**Byers Gill Solar
EN010139**

3.3 DCO Schedule of Changes

Revision 6 – 8 January 2025

Drawing Title
Street Works, Public Rights of Way & Access Plans
 Sheet 11 of 13
APFP Regulation 5(2)(k)

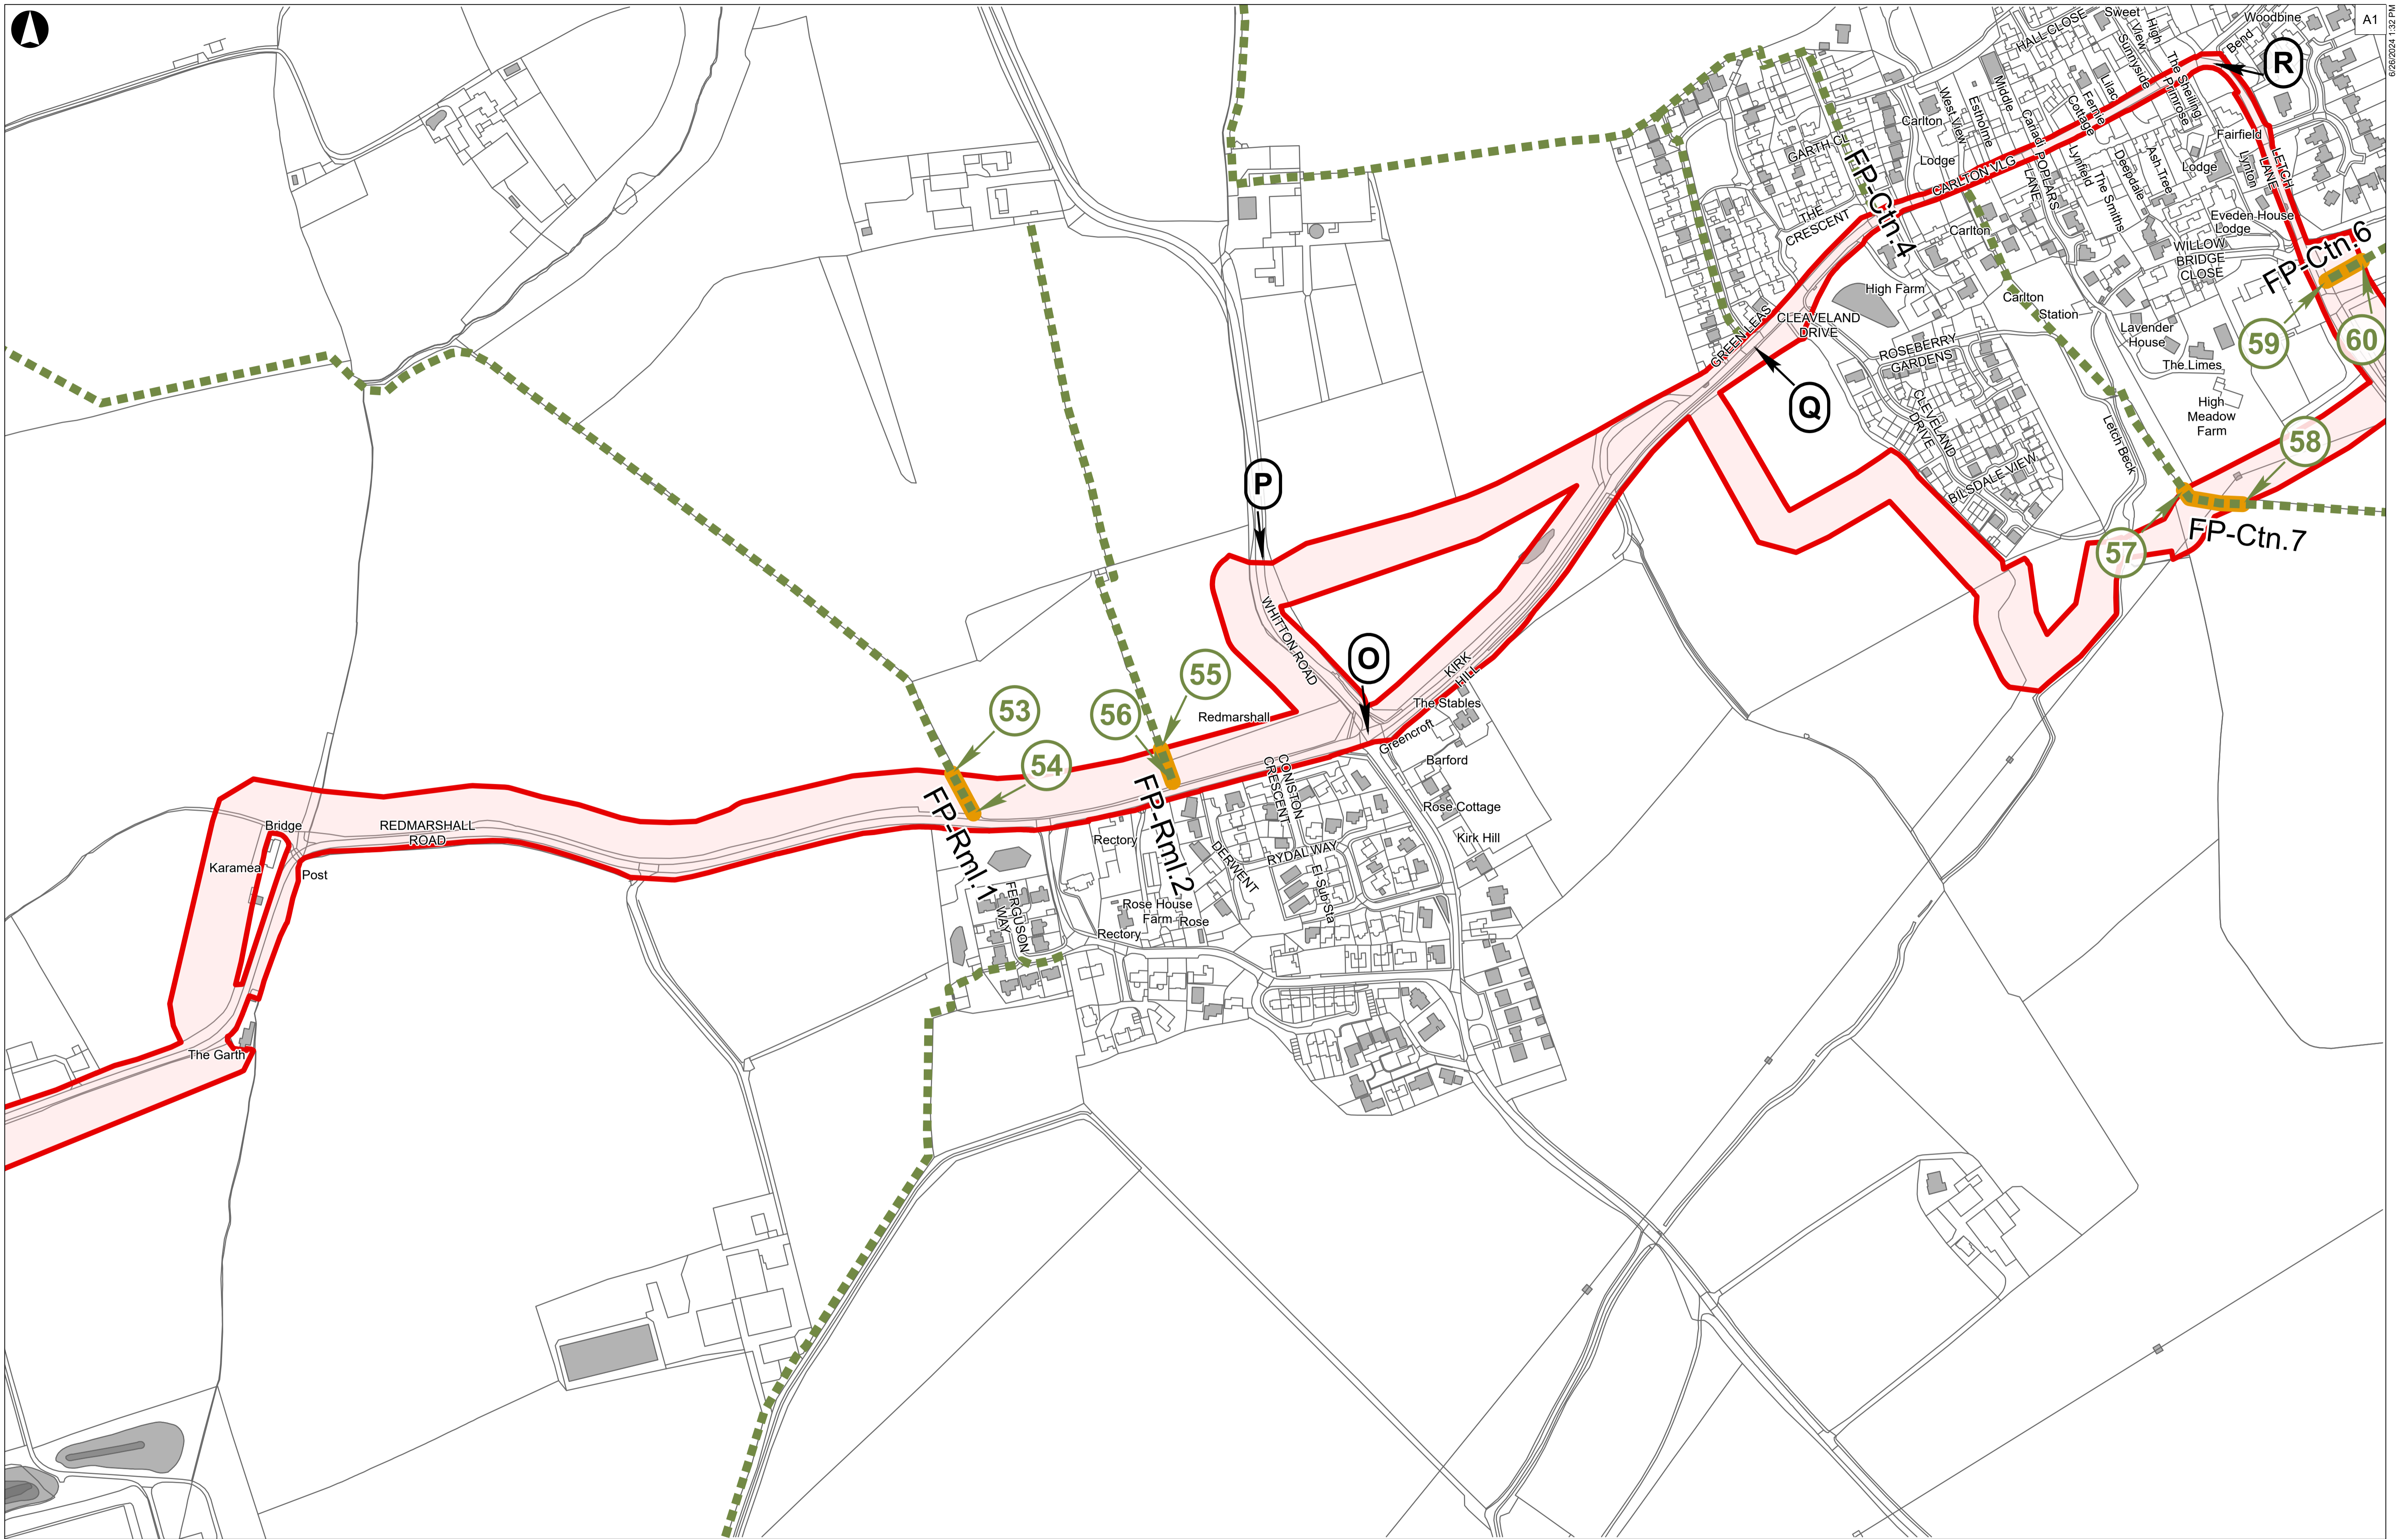
<p>Within the table of street works in Schedule 3, two rows have been added as follows:</p> <table border="1" data-bbox="580 802 1267 1310"> <tr> <td data-bbox="580 802 775 1054"><u><i>Parish of Bishopton</i></u></td> <td data-bbox="775 802 943 1054"><u><i>Folly Bank</i></u></td> <td data-bbox="943 802 1267 1054"><u><i>Cable works beneath the width of street as shown with reference CC5 on sheet 9 of the street works, public rights of way and access plans.</i></u></td> </tr> <tr> <td data-bbox="580 1054 775 1310"><u><i>Parish of Redmarshall</i></u></td> <td data-bbox="775 1054 943 1310"><u><i>Redmarshall Road, in the vicinity of Morington Bridge</i></u></td> <td data-bbox="943 1054 1267 1310"><u><i>Cable works beneath the width of street as shown with reference CC6 on sheet 11 of the street works, public rights of way and access plans.</i></u></td> </tr> </table>	<u><i>Parish of Bishopton</i></u>	<u><i>Folly Bank</i></u>	<u><i>Cable works beneath the width of street as shown with reference CC5 on sheet 9 of the street works, public rights of way and access plans.</i></u>	<u><i>Parish of Redmarshall</i></u>	<u><i>Redmarshall Road, in the vicinity of Morington Bridge</i></u>	<u><i>Cable works beneath the width of street as shown with reference CC6 on sheet 11 of the street works, public rights of way and access plans.</i></u>	<p>These two rows have been added to provide street works descriptions for two locations where the Applicant proposes to carry out cabling works across the width of a street for the purpose of delivering the off-road cable route. These descriptions are included as a correction to Revision 1 of the dDCO.</p> <p>Corresponding amendments have been made to the Street Works, Public Rights of Way and Access Plans to indicate these locations.</p>

<u><i>Parish of Bishopton</i></u>	<u><i>Folly Bank</i></u>	<u><i>Cable works beneath the width of street as shown with reference CC5 on sheet 9 of the street works, public rights of way and access plans.</i></u>						
<u><i>Parish of Redmarshall</i></u>	<u><i>Redmarshall Road, in the vicinity of Morington Bridge</i></u>	<u><i>Cable works beneath the width of street as shown with reference CC6 on sheet 11 of the street works, public rights of way and access plans.</i></u>
